From: Debbie Roberts [REDACTED]
Sent: 05 January 2023 10:20
To: Morgan and Morecambe OWFTA
Cc: Anthony Akrigg
Subject: FW: Morecambe/Morgan Offshore Windfarm.

From: Anthony Akrigg [REDACTED]
Sent: 04 January 2023 13:28
To: Debbie Roberts [REDACTED]
Subject: Morecambe/Morgan Offshore Windfarm.

Further to our discussion earlier I just wanted to raise a couple of concerns I have in relation to the onshore Transmission Assets.

I've read the Scoping Report for the EIA October 2022 and in particular Section 8.4 Noise & Vibration which has lead to a number of queries as below;

**Figure 1.3: Construction Vibration - Location Plan**

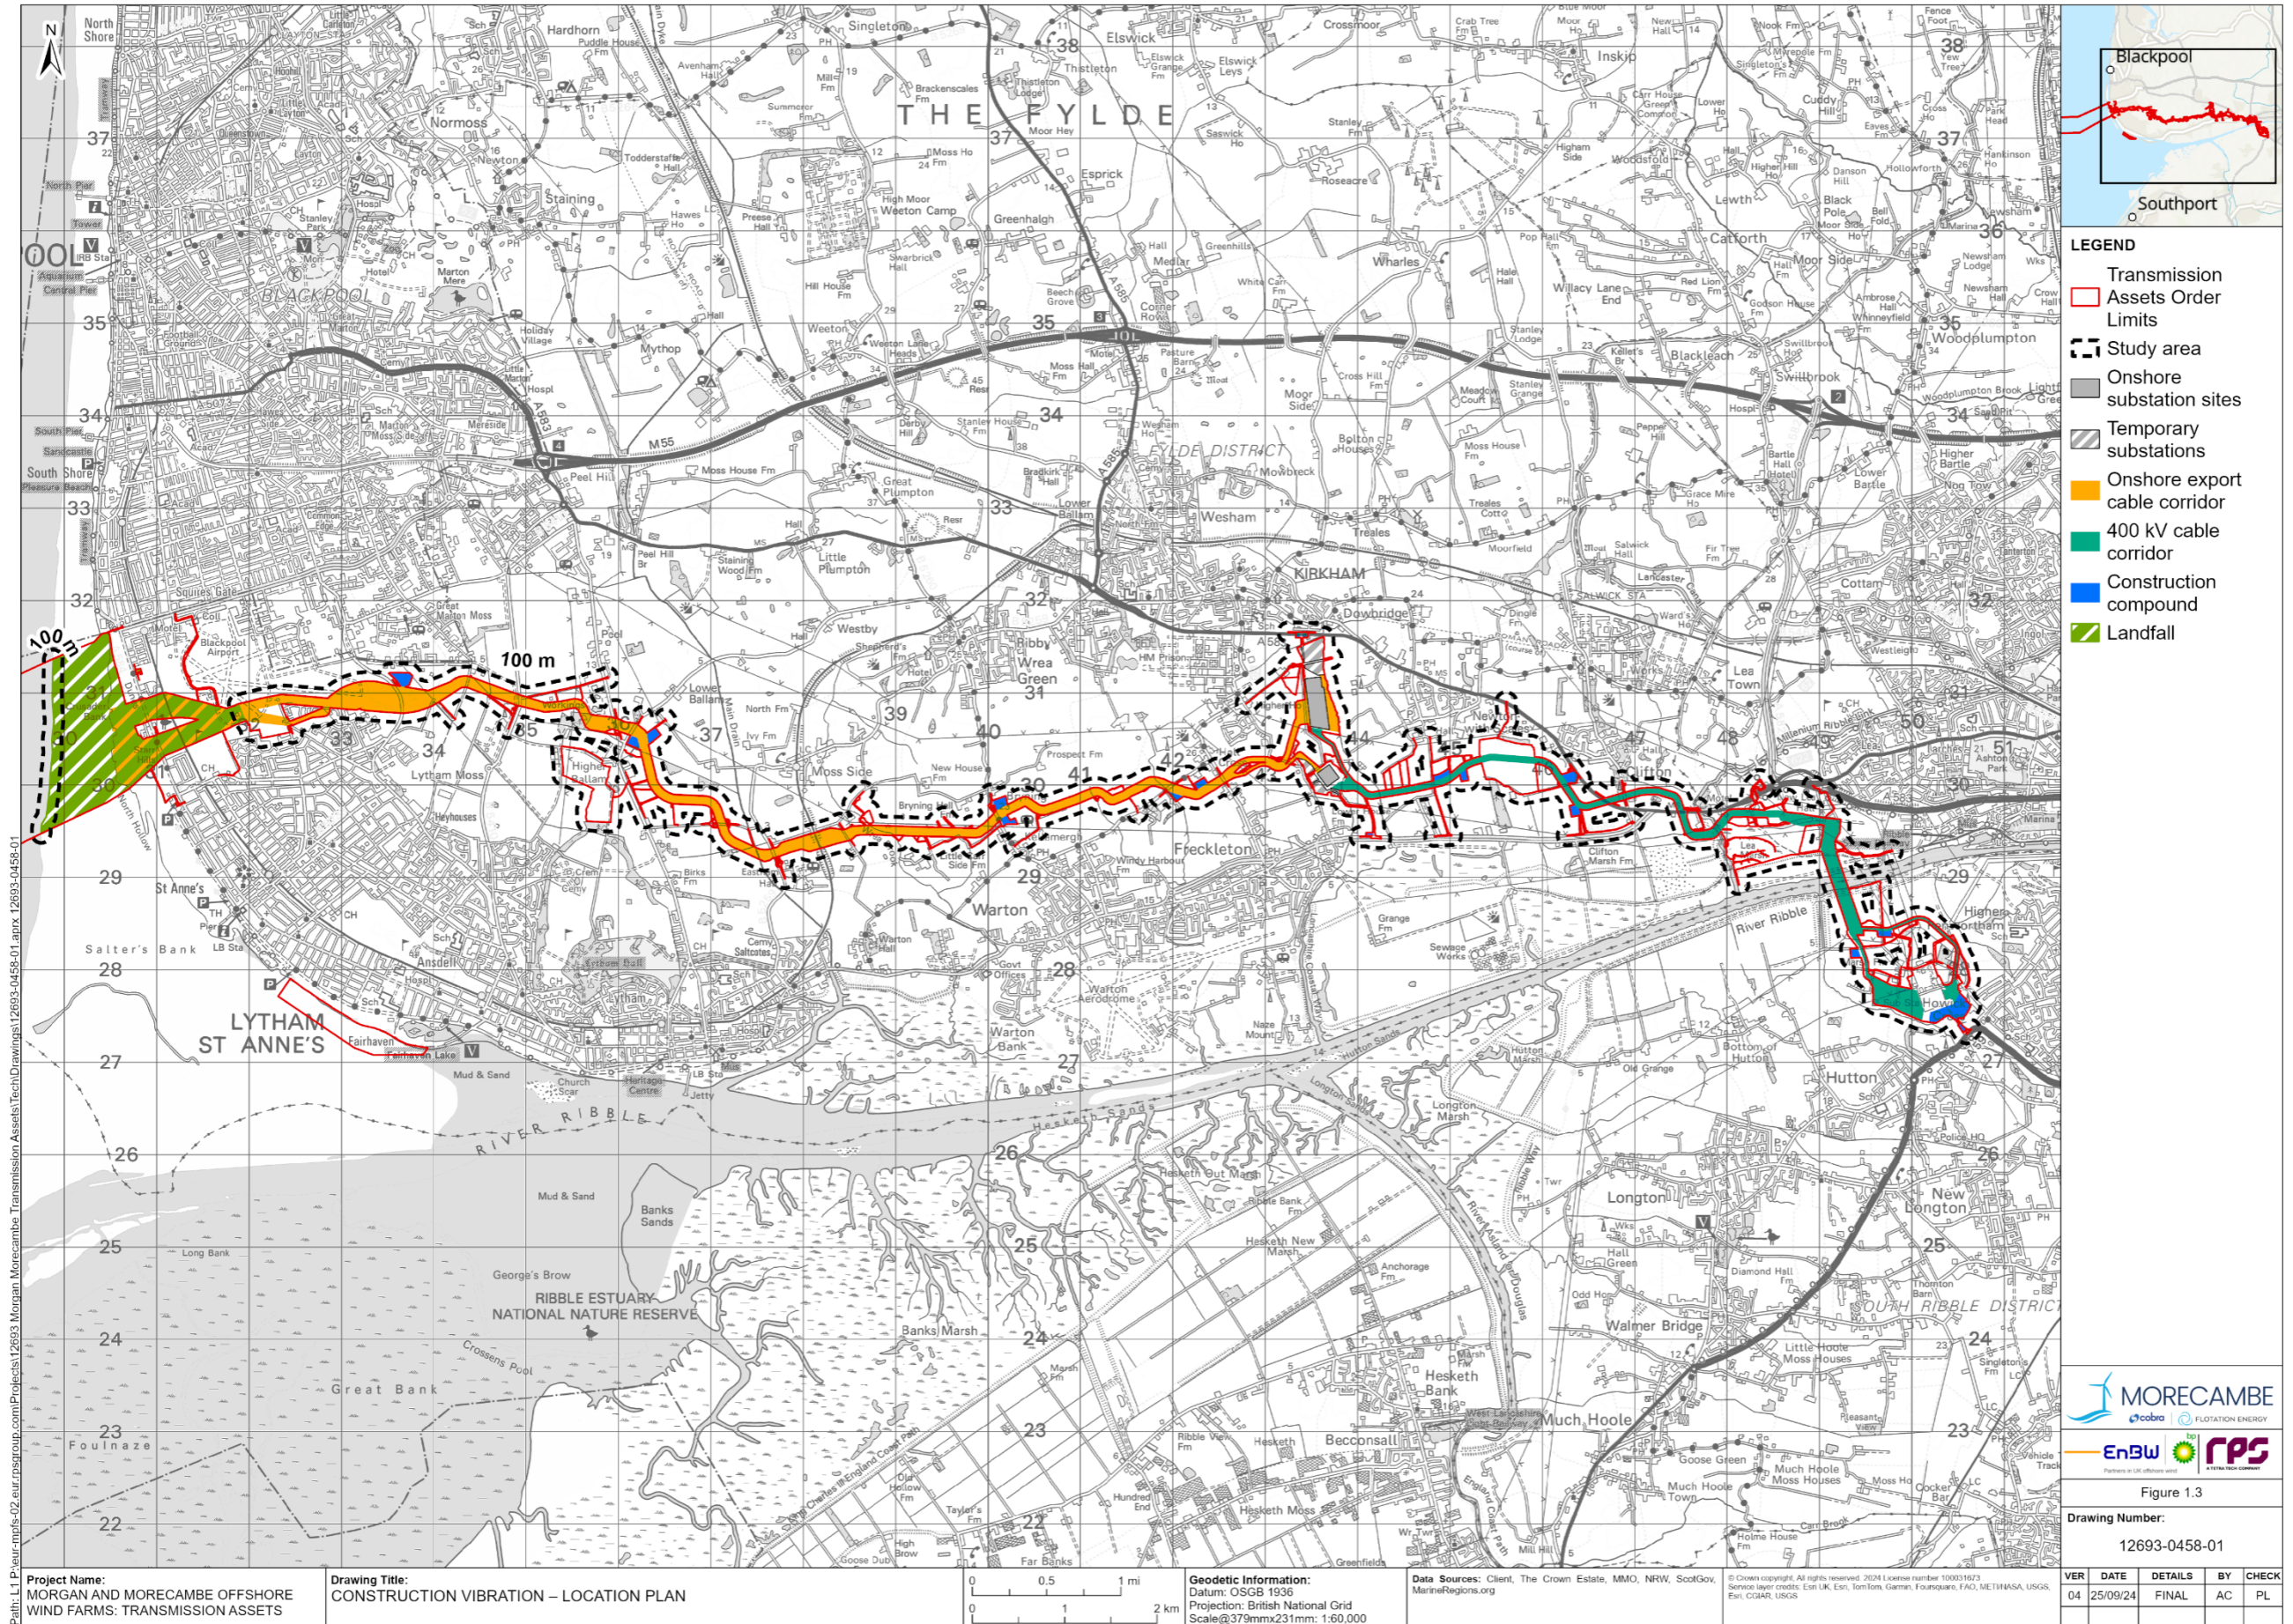
- 8.4.2.3: the final bullet point refers to '*vibration sensitive receptors within 100m*'; experience has shown that the effects of piling etc can cause problems at receptors beyond 100m so just wondered where the 100m has come from and the technical reasoning behind it?

Figure 1.1: Operational noise sensitive receptors (Morgan Onshore Substation)

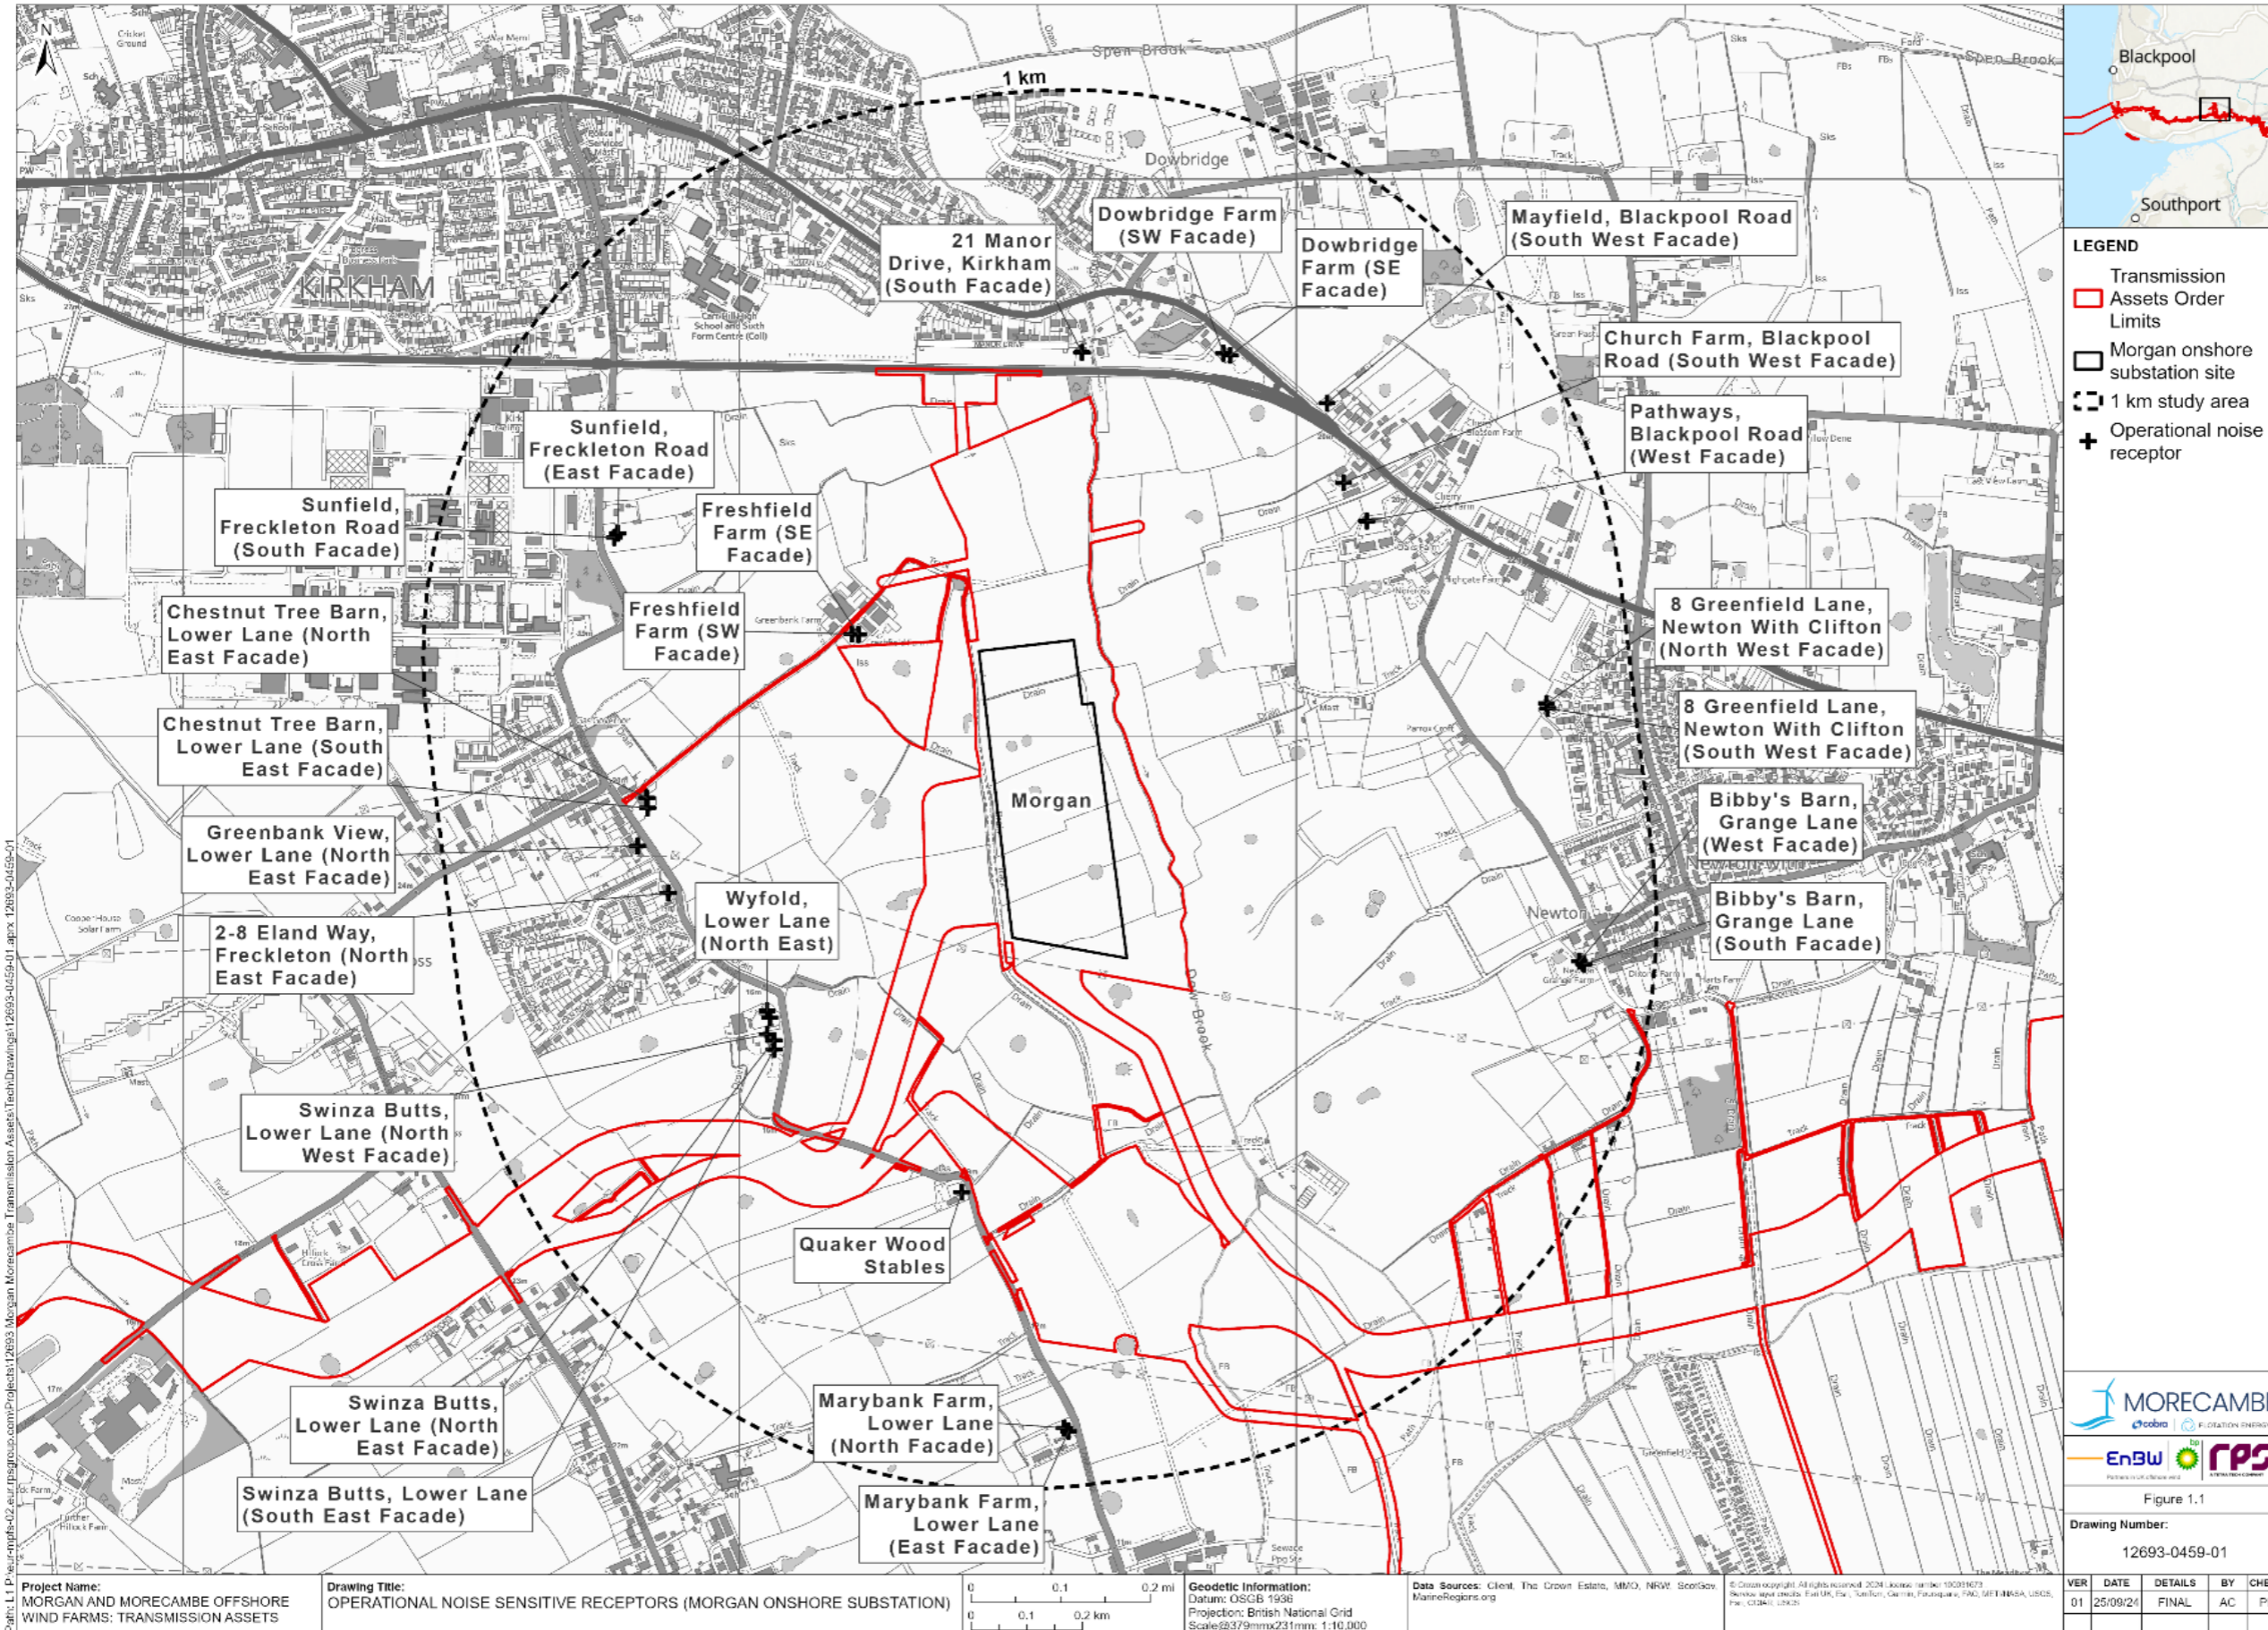
- Operational noise at the sub-station at Penwortham has been discounted; are we right to presume this will be the case? Previous stations at Howick Cross Lane have cooling operations that produce operational noise which has been the subject of noise impact assessments – will the new transmission assets just be essentially plugged into the national grid or will there be the need for any potentially noisy operations (outside maintenance)?
